**Consultation Response from KC,
Conservation & Design**

2025/93394 Rowley Mills, Penistone Road, Fenay Bridge, Huddersfield, HD8 0LE

Erection of 3 storey front extension and 2 storey rear extension of Rowley Mills with associated car park amendments, ancillary structures and landscaping; first floor roof extensions, car park amendments and landscaping at International House with new access infrastructure and pedestrian crossing facility

Date Responded:23/3/26

Above - Front Elevation

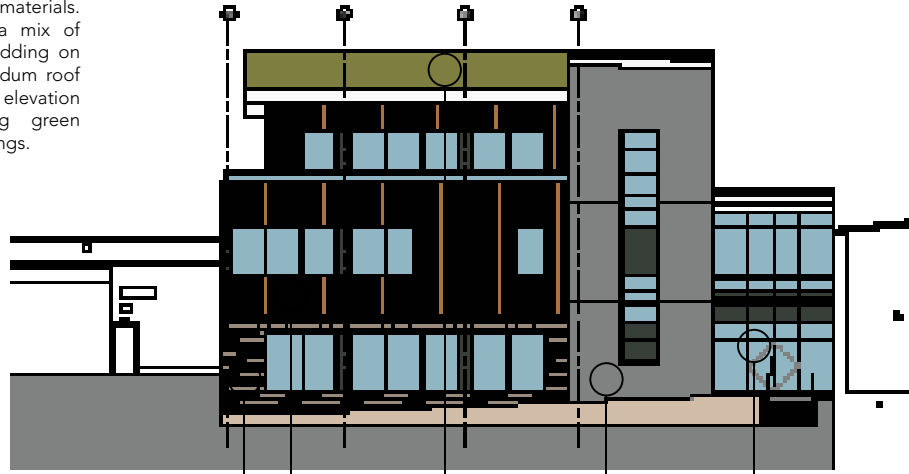
At the front of the main block of buildings an existing 1940's stone house is proposed to be replaced with a new 3 storey building extension. The scale is higher than existing buildings, but due to the mature trees at the front and the design and materials, it is unlikely that this extension would be visible in the landscape or within views from Woodsome Hall. The materials are appropriate and include a plinth of natural coursed stone, timber cladding with a natural finish and dark grey cladding with a sedum roof in an organic form. The palette of materials and colour finishes should ensure that the materials would not appear to be unduly prominent in the landscape from distant view points.
